Geotechnical Peer Review – Response SUB4

Helix Design Build – 6922 SE 33rd ST

11.28.22

BUILDING SECTION 'E'
SCALE: 1/4" = 1' - 0"

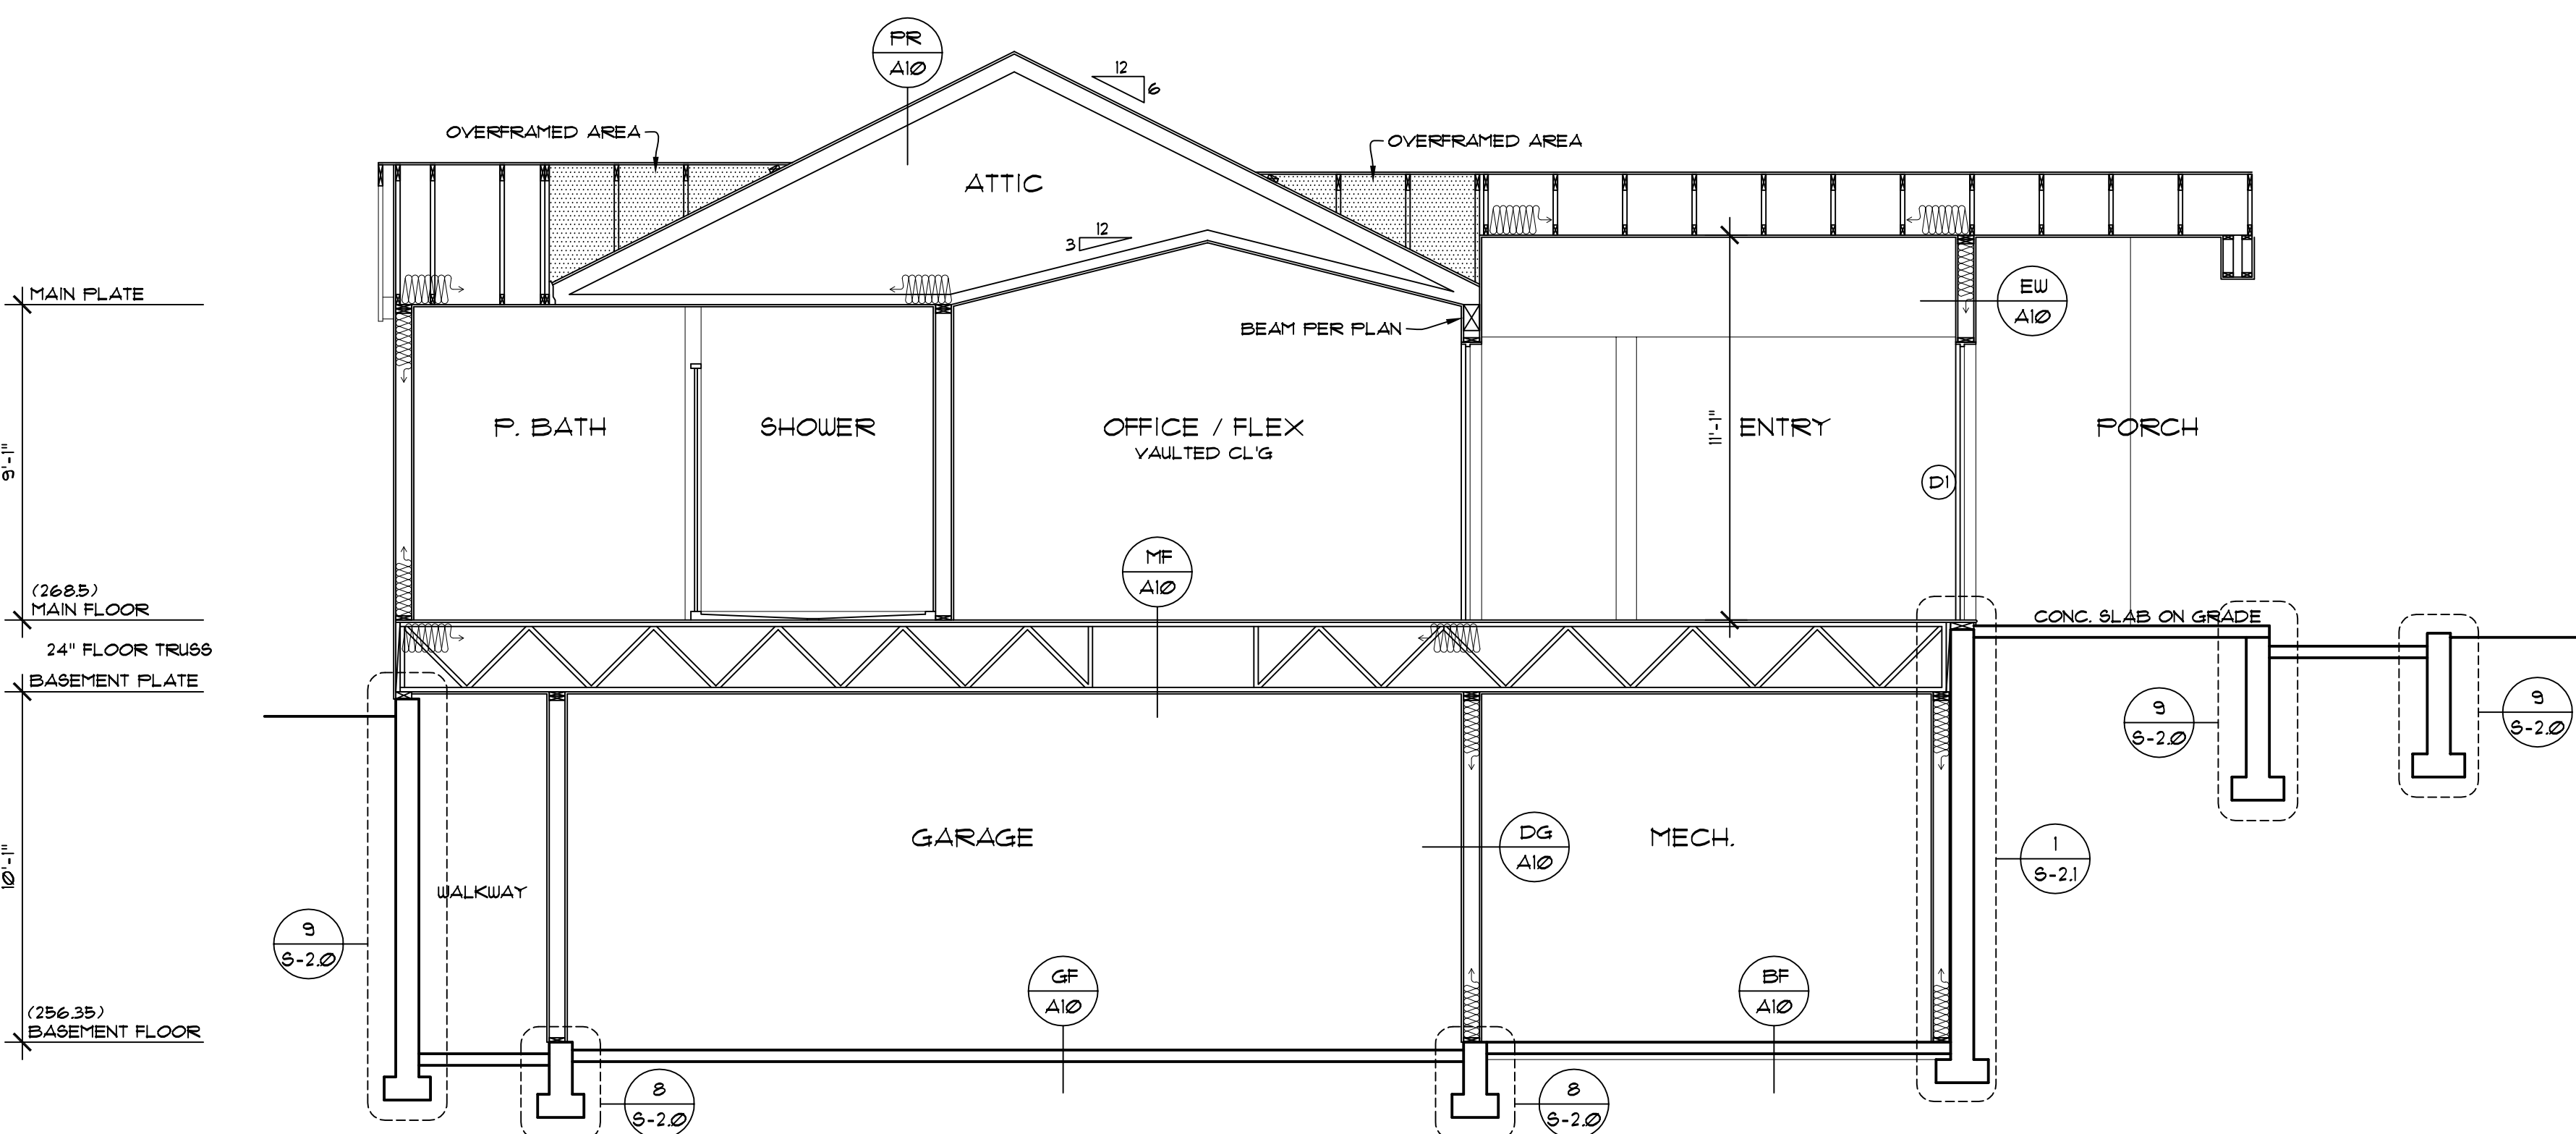
There was only one remaining comment to address, which pertained to possible surcharge from the main level foundation wall/footing to the basement level retaining wall – as shown in section 'E' on sheet A10. Section 'E' has been updated to graphically illustrate a 1:1 relationship from bottom of footing to bottom of footing. Also, we have added a new partial section 'G' (sheet A10) to illustrate the same relationship where the gap between walls is the narrowest. At the recommendation of our engineer of record, we are now showing a level crawl space grade throughout. We have removed the basement level crawl space access in order to achieve this. The only access is now via the floor system above.

The plan set (along with the updated/newly added sections) has been re-reviewed by our geotech and structural engineer of record – see attached Geo Addendum_SUB4 and Engineer response_SUB4. Both confirm that this solution eliminates any potential surcharge condition.

- **Update to section 'E' – sheet A10**
- **New partial section 'G' – sheet A10**
- **Corresponding updates to sheets A1**
